KITTITAS COUNTY DEPARTMENT OF PUBLIC WORKS

MEMORANDUM

SUBJECT: Happy Trails Plat

Our department has reviewed the Short Plat application and has the following comments:

HAPPY TRAILS
SECTION 6, T. 17 N., R. 19 E., W.M.
KITITAS COUNTY, WASHINGTON
- PRELIMINARY PLAT -

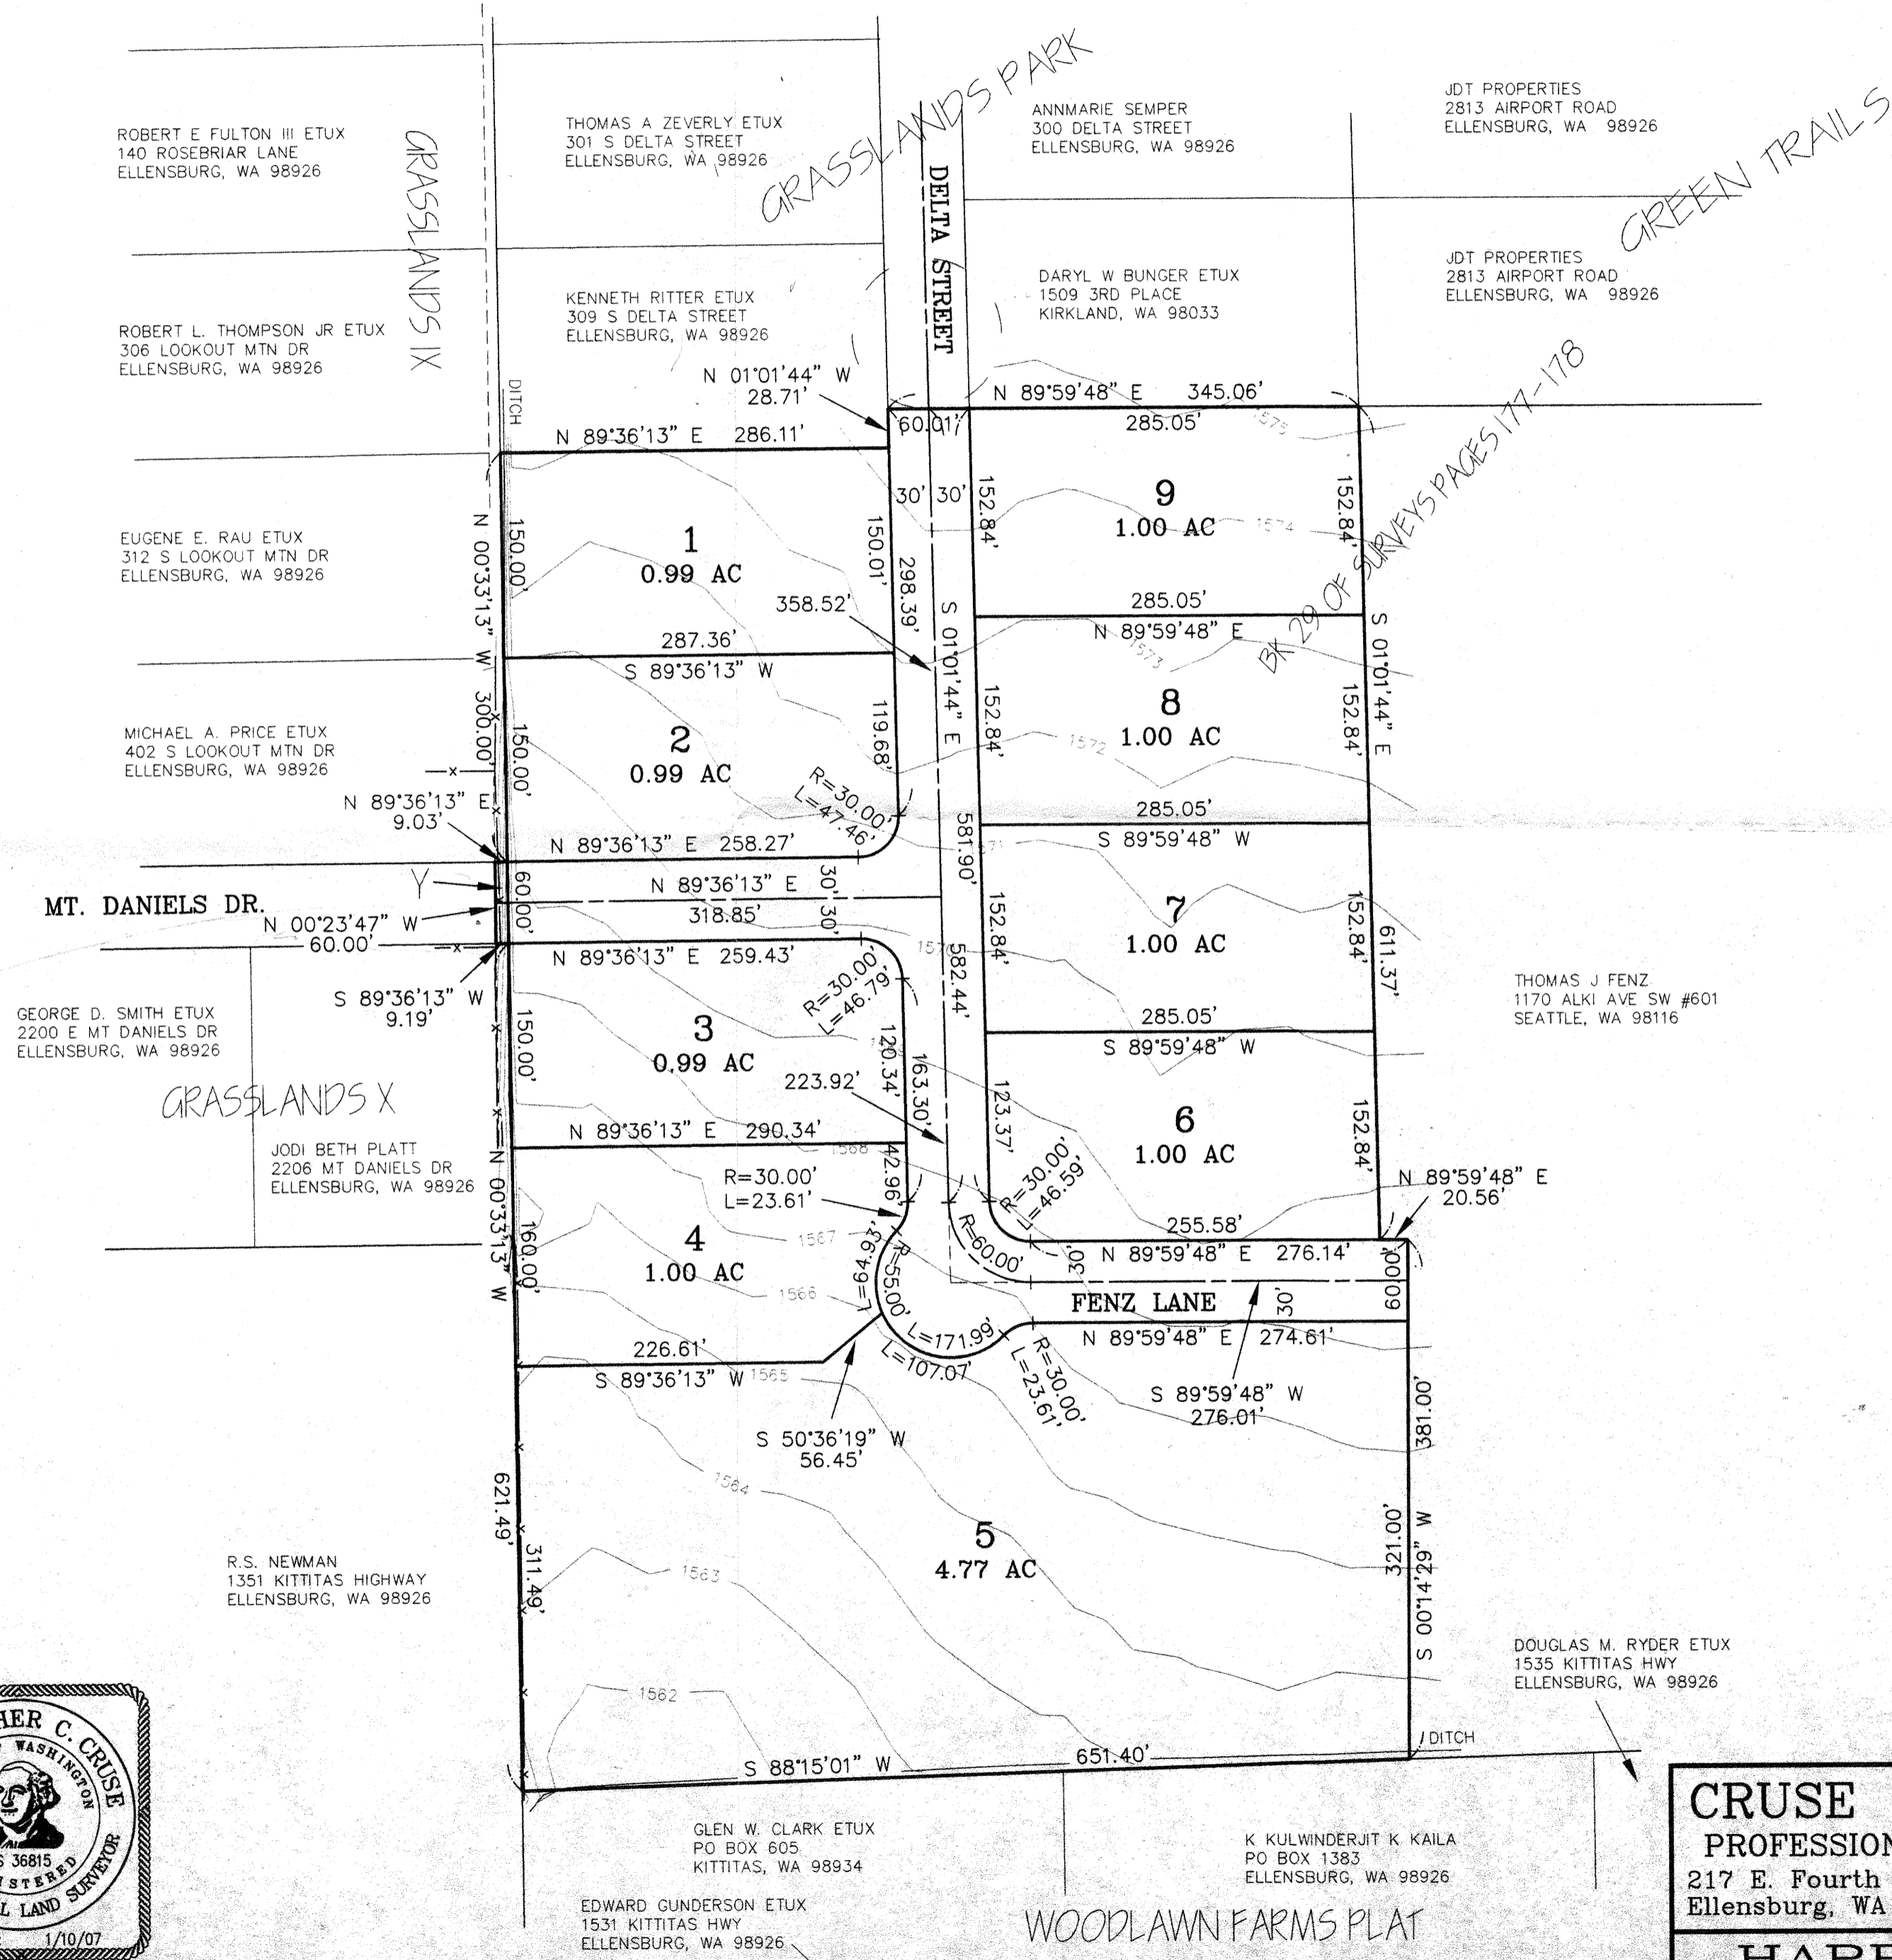
1. Road Name(s) "Fenz Lane": Road names shall be subject to the approval of the Kittitas County Department of Public Works. Contact the Kittitas County Rural Addressing Coordinator at (509) 962-7523 for more information.
2. Newly Proposed Road: The newly proposed road(s) appear to be extensions of Delta Street, Mt. Daniels Drive and Quartz Mtn. Drive, as depicted by the 60' right of way, this would appear to indicate that this is being proposed as a county "on-system" road, similar to the Grasslands Park Plat extension of Quartz Mtn Drive. Delta Street, Mt. Daniels Drive and Quartz Mtn. Drive are designated as Class 09 Rural Local Access Roads (per Kittitas County Road Standards 12.03.030, C). The applicant and/or designated representative shall contact the Kittitas County Department of Public Works to discuss the particulars of the newly proposed road at their earliest convenience.

3. Internal Roads: The newly proposed road shall be constructed as defined in Kittitas County Road Standards 12.03.010 Road Classifications and 12.03.020, C.

4. Road Design Standard: Per current Kittitas County Road Standards Table 4-2:
- a. Road shall be constructed to a total paved width of 26' with a minimum of 22' traveled way.

- b. Access shall be constructed within a 60' wide right-of-way dedicated to the public.
5. Road Plans: Developers shall submit road plans as follows: Plan and profile drawings for all roads shall be submitted to the county engineer on film or linen sheets twenty-two inches by thirty-six inches in size, and receive his approval before proceeding with construction. The drawing standards used in preparing the drawings shall conform to the current drawing standards employed by the department of public works. All plans for roads, drainage, and utility construction are to be designed and prepared by a licensed professional engineer. Staking for road construction and adequate survey control for utility construction shall be provided at the subdivider's expense. **No work may be started until such plans are approved.** (see current Kittitas County Road Standards 12.08.010 for more detailed information).
